From: Amy Myer <Amy.Myer@arun.gov.uk>
Sent: 24 June 2020 17:46
To: Planning.Responses <Planning.Responses@arun.gov.uk>
Cc: Daniel Vick <Daniel.Vick@arun.gov.uk>
Subject: FW: AL/34/20/PL & AL/35/20/L - Norton Farm House - EXTENSION OF TIME/PLANNING COMMITTEE CASE

From: David Bennett [REDACTED]
Sent: 24 June 2020 15:24
To: Amy Myer <Amy.Myer@arun.gov.uk>
Subject: Re: AL/34/20/PL & AL/35/20/L - Norton Farm House - UPDATE

LOCATION PLAN AND BLOCK PLAN

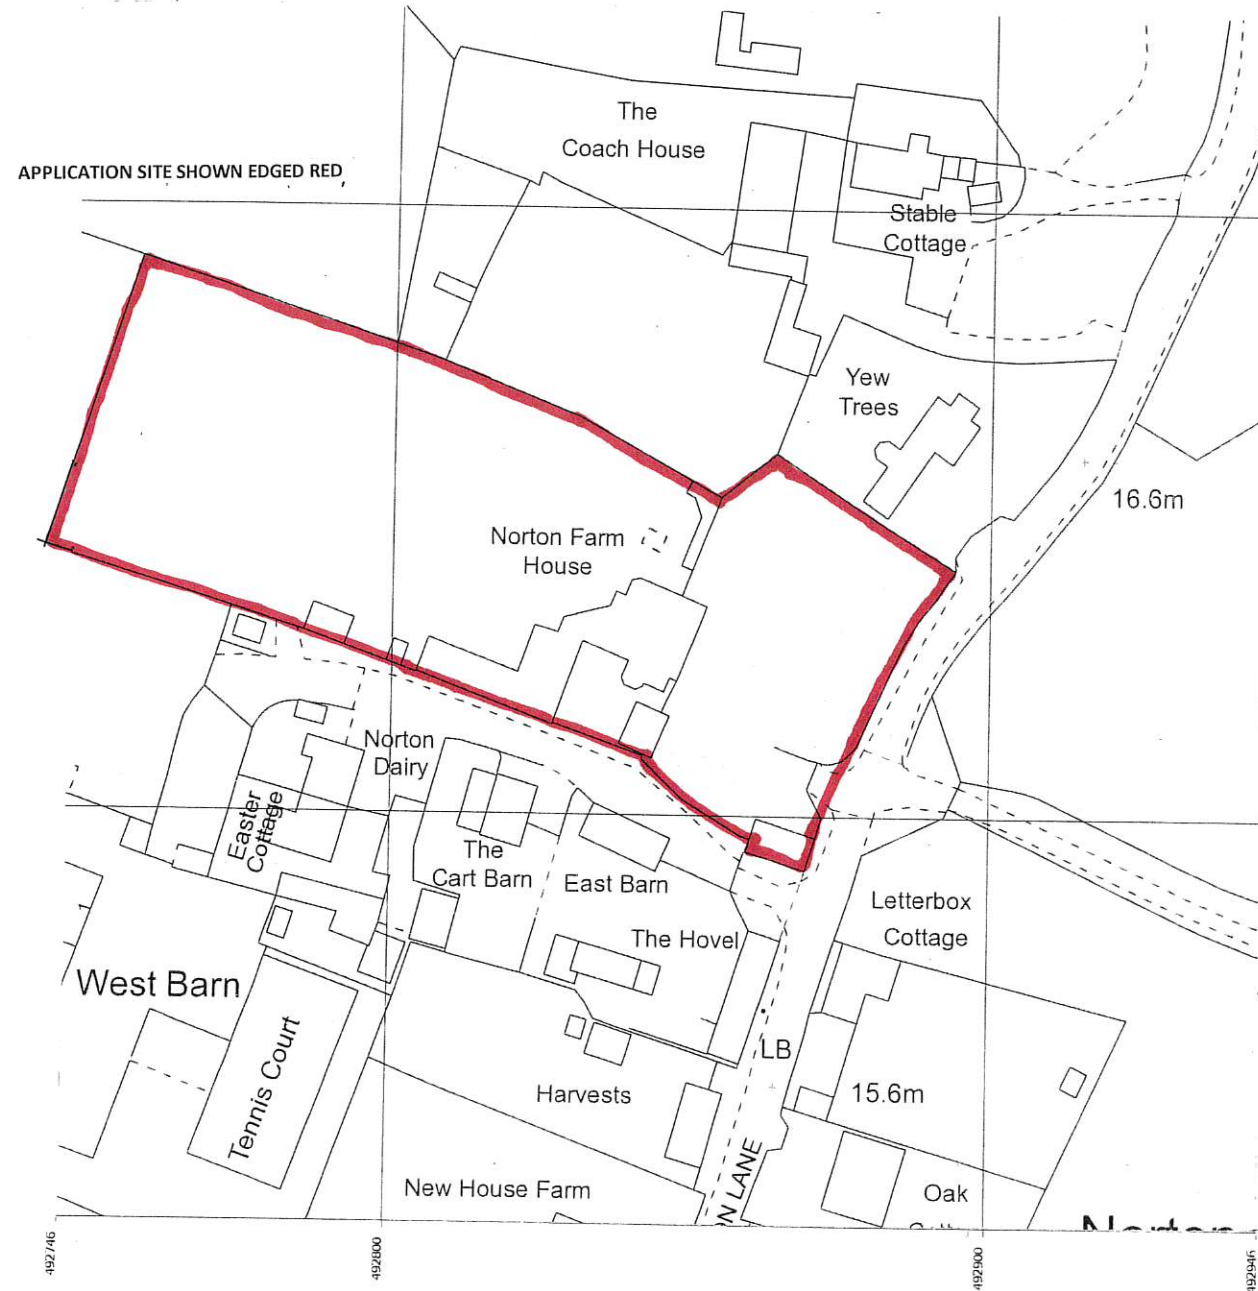
1. Vehicle access plan – please amend location plan and block plan with drawing title 'Vehicle access plan' and then on block plan image show edged in red the application buildings and with the double gates and vehicle access marked in red with arrow and annotation and same on site location image 'existing double gate access to site' in red with arrow, so it's all clearer (since we received a neighbour objection on this matter)
2. Site photos – of rest of the site, farmhouse, courtyard where existing playroom building is, area where new garage will go

Many thanks for your email. I will take the photos you have asked for tomorrow and email them to me with the marked up plans as requested. There were some photos of the playroom building and farmhouse submitted with the application but I will take some more to be on the safe side.
